13th October 2022

Response to Revised Planning Applications  
Nos. **2021/62/93006/E**, **2021/65/93007/E** and **2021/62/92969/E** for the  
development **of Yew Tree Farm, Farnley Tyas.**

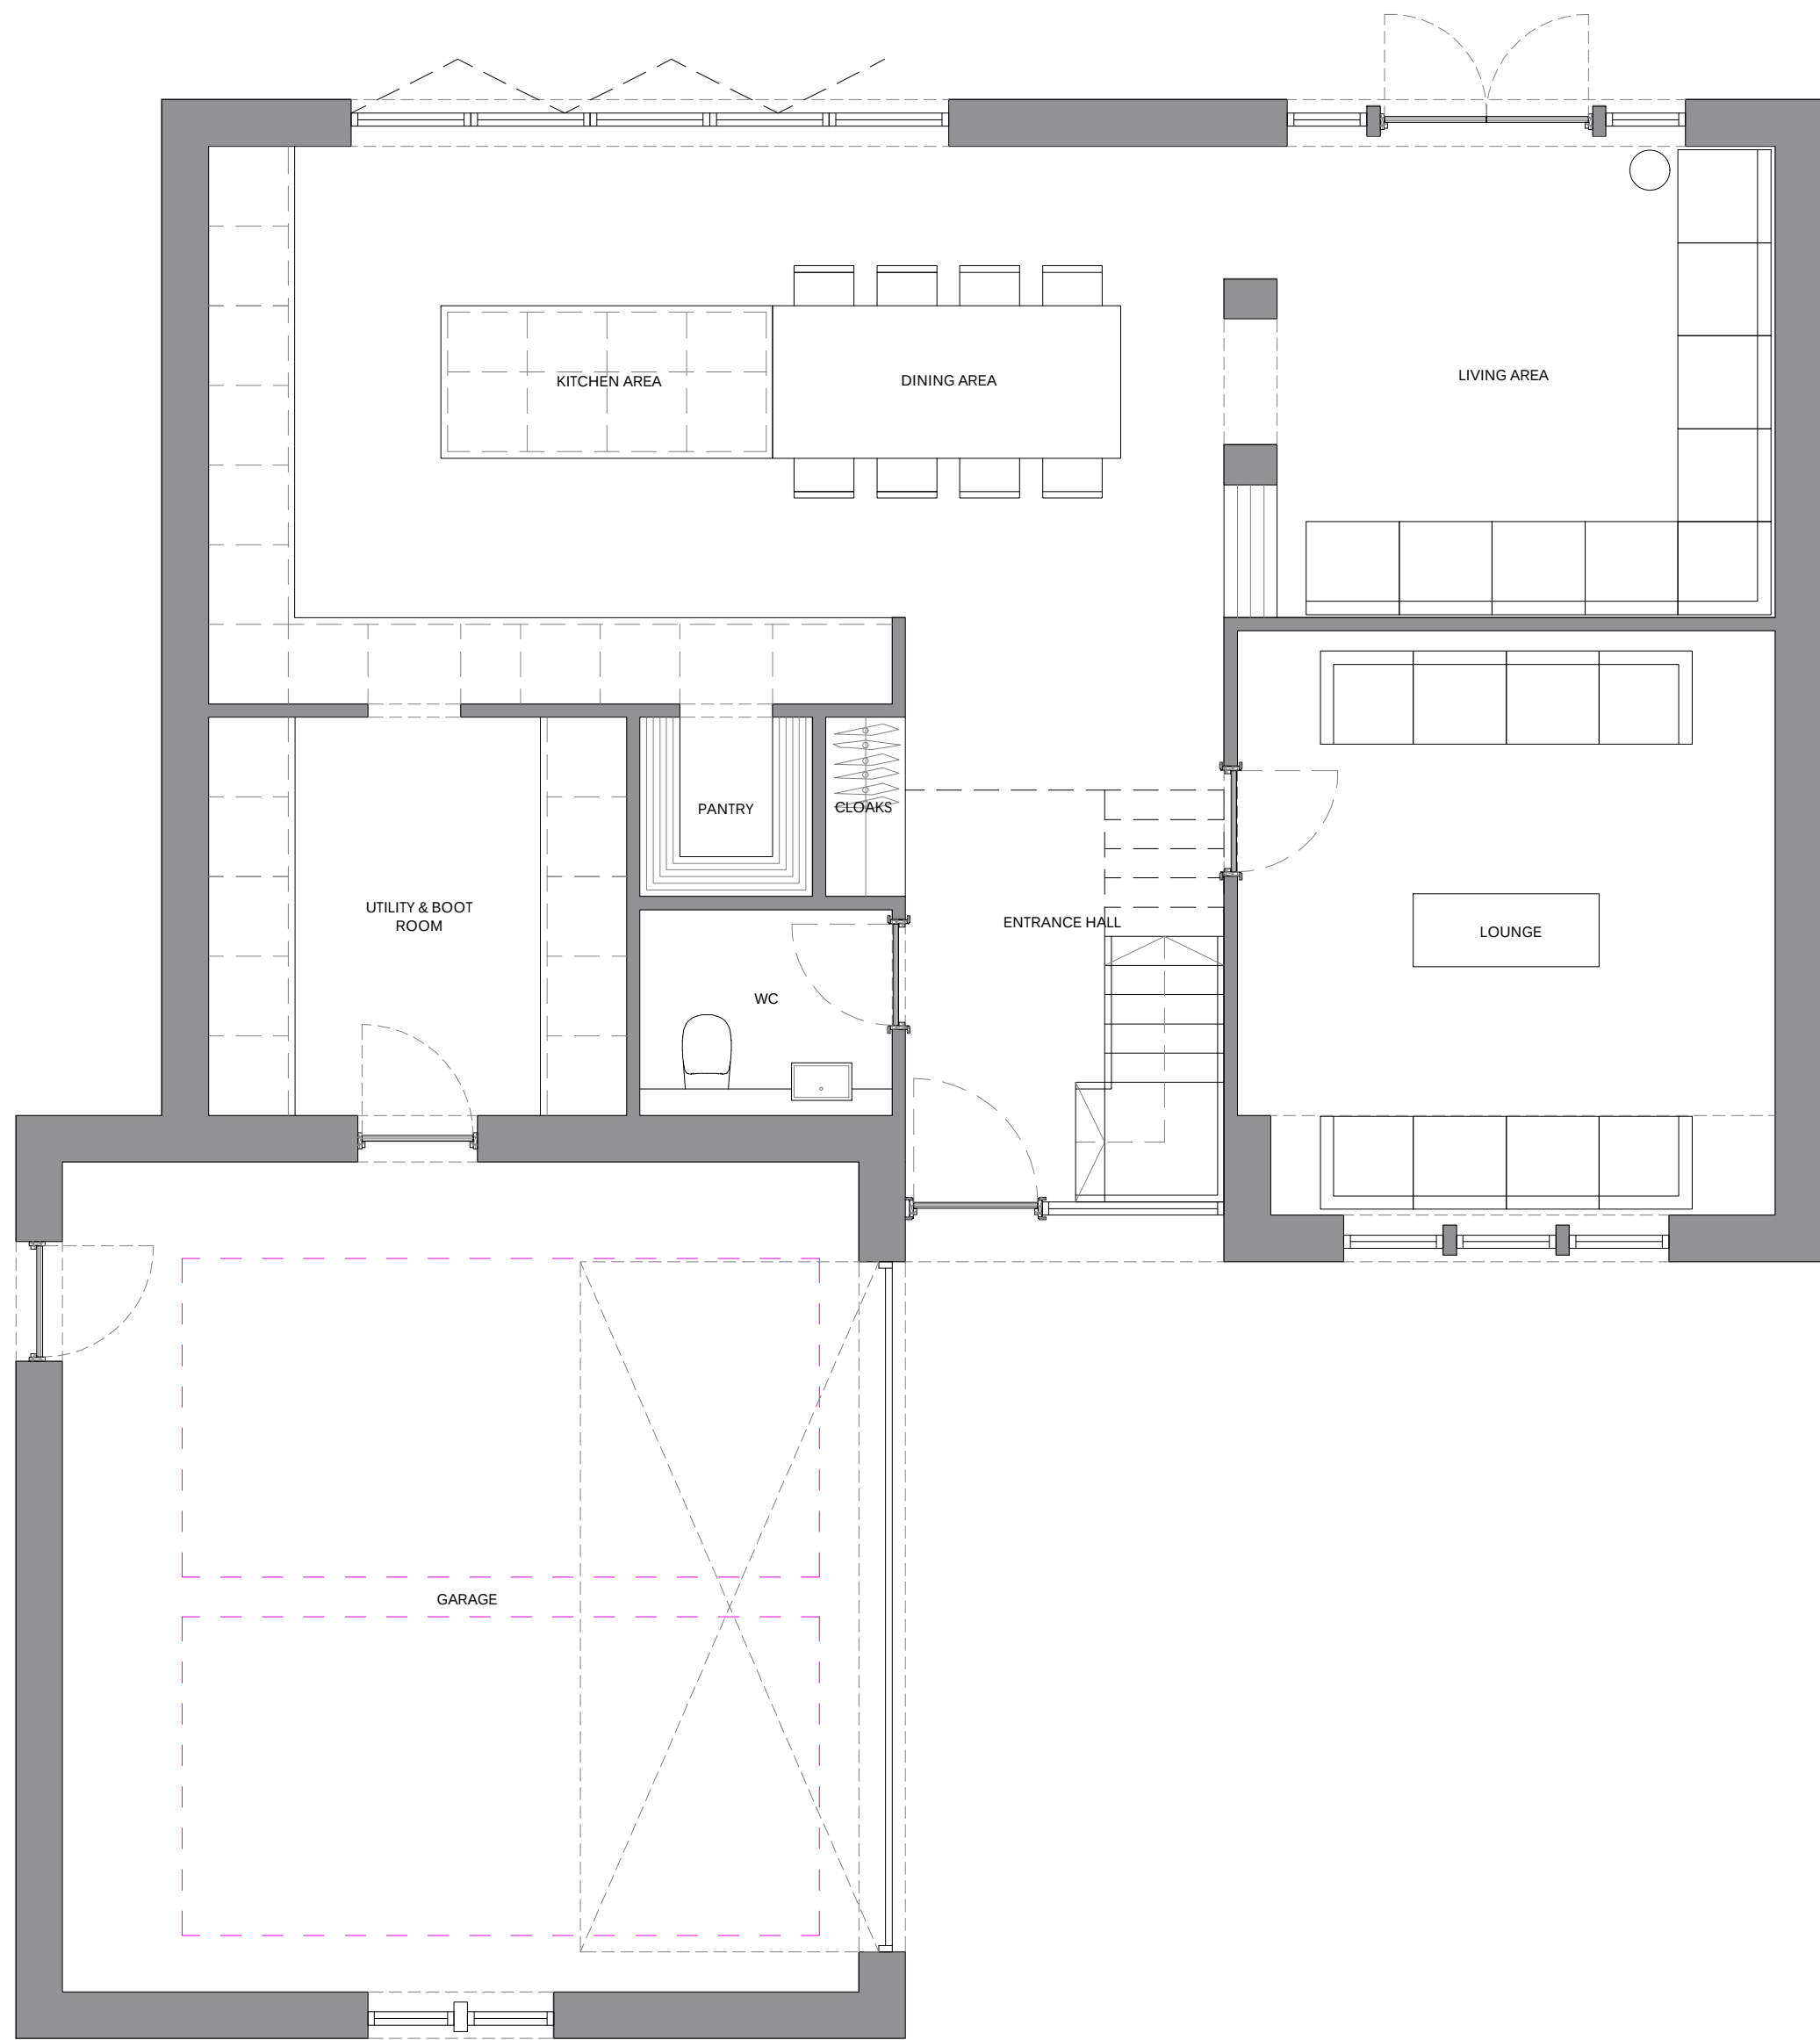
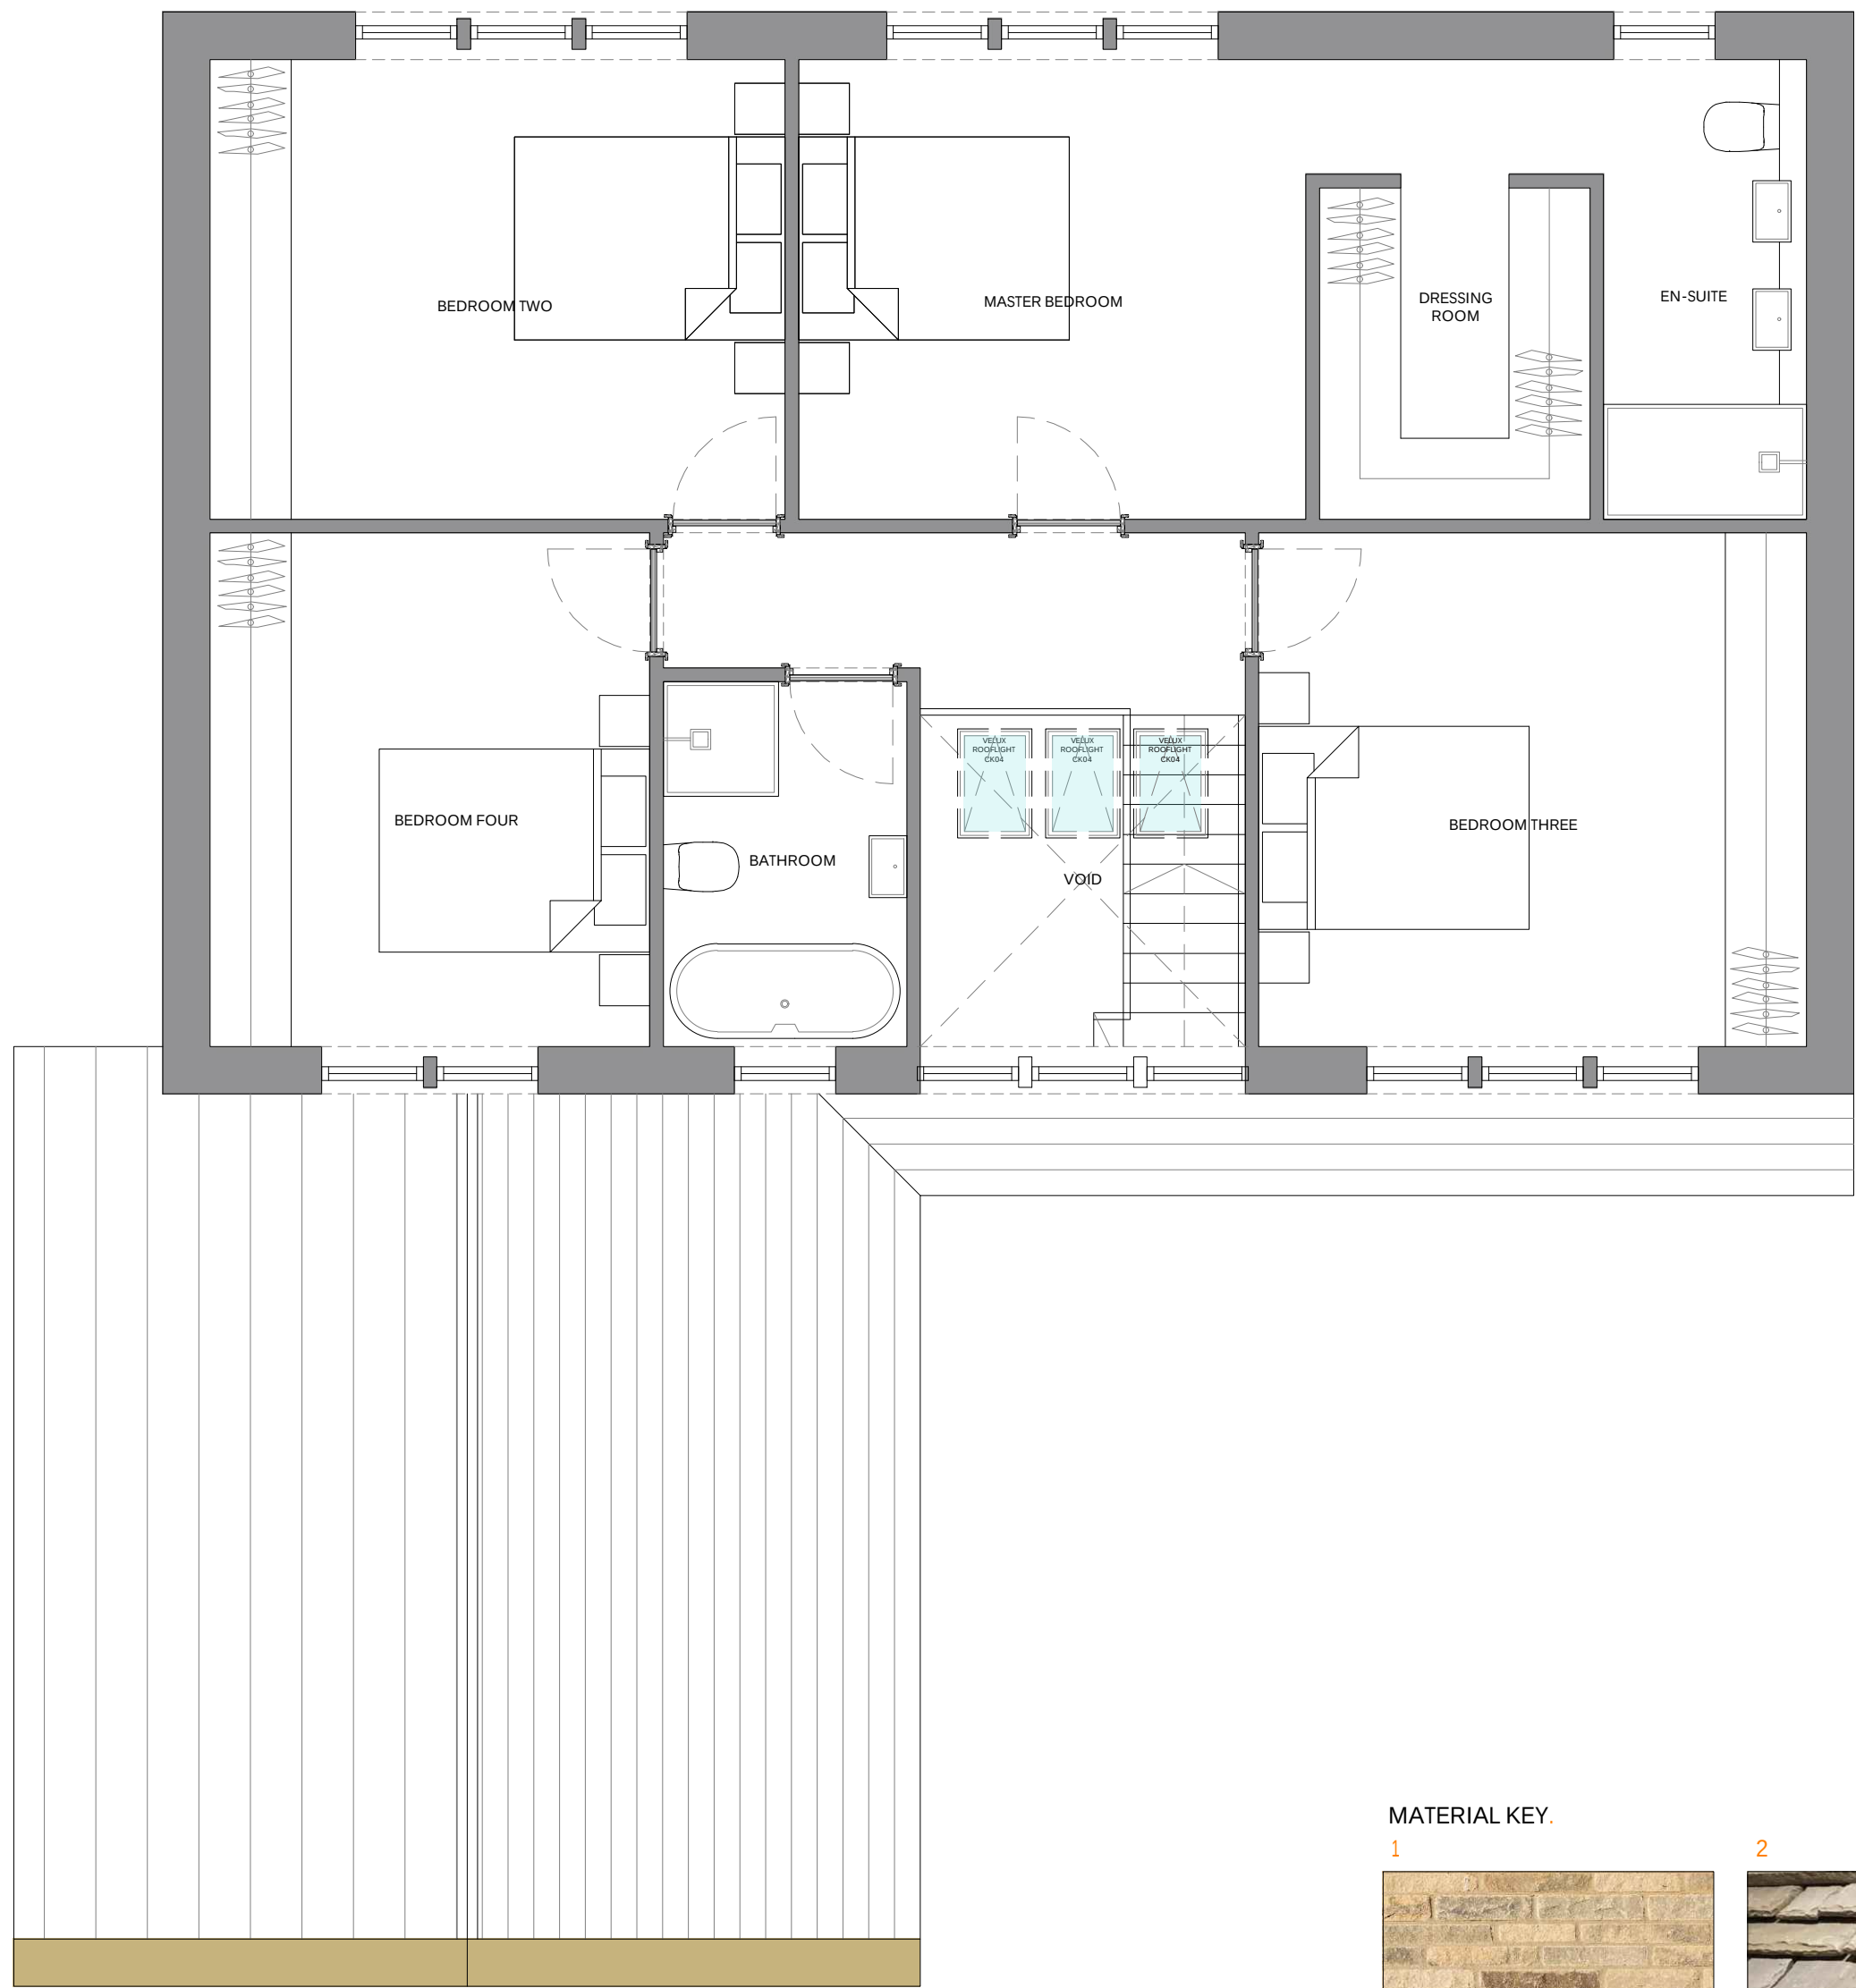
**Plot 9** - proposed ground floor level is approx. 1m higher than existing ground levels. The proposed GFL will be at the same level as the bedrooms of the adjacent homes one of which is listed, 51/53 The Village. It is 5 metres closer to 51/53 The Village than the

existing east wall of the single storey agricultural barn. There are no ridge levels shown but by comparing the house designs we estimate this house will be approx. 8m high and with the proposed orientation will have 2 floors of multiple windows overlooking 51/53 The Village and New Lane Barn. This will have a dominating effect and greatly reduce the visual and residential amenity of these existing properties.

**Plot 9** - will also dominate the adjacent listed building the Milking Shed. It is only a few metres away and the proposed ridge level is approx 3m higher than the existing Milking Shed.
